**PLANNING APPLICATION CONSULTATION RESPONSE**

<b>Application Number:</b>	3/2021/0356
<b>Location:</b>	Wharf Farm, Green Lane, Chipping
<b>Proposal:</b>	Modernization of agricultural buildings, replacing existing housing with a complete dairy unit to accommodate 70no. cows

**Lead Local Flood Authority (LLFA) Position**

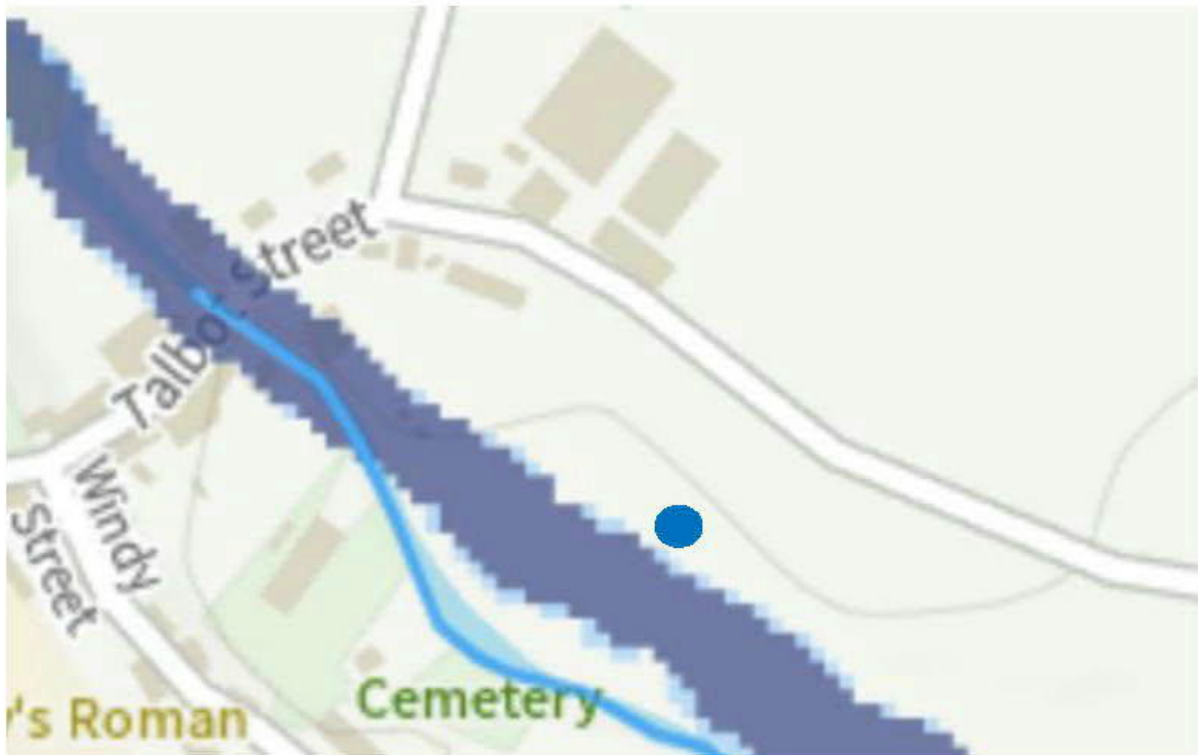
1. Confirmation that the proposed pond does not sit within flood zone 2 or 3.
2. Evidence to confirm that a free-flowing outfall can be achieved without backing up or flooding.
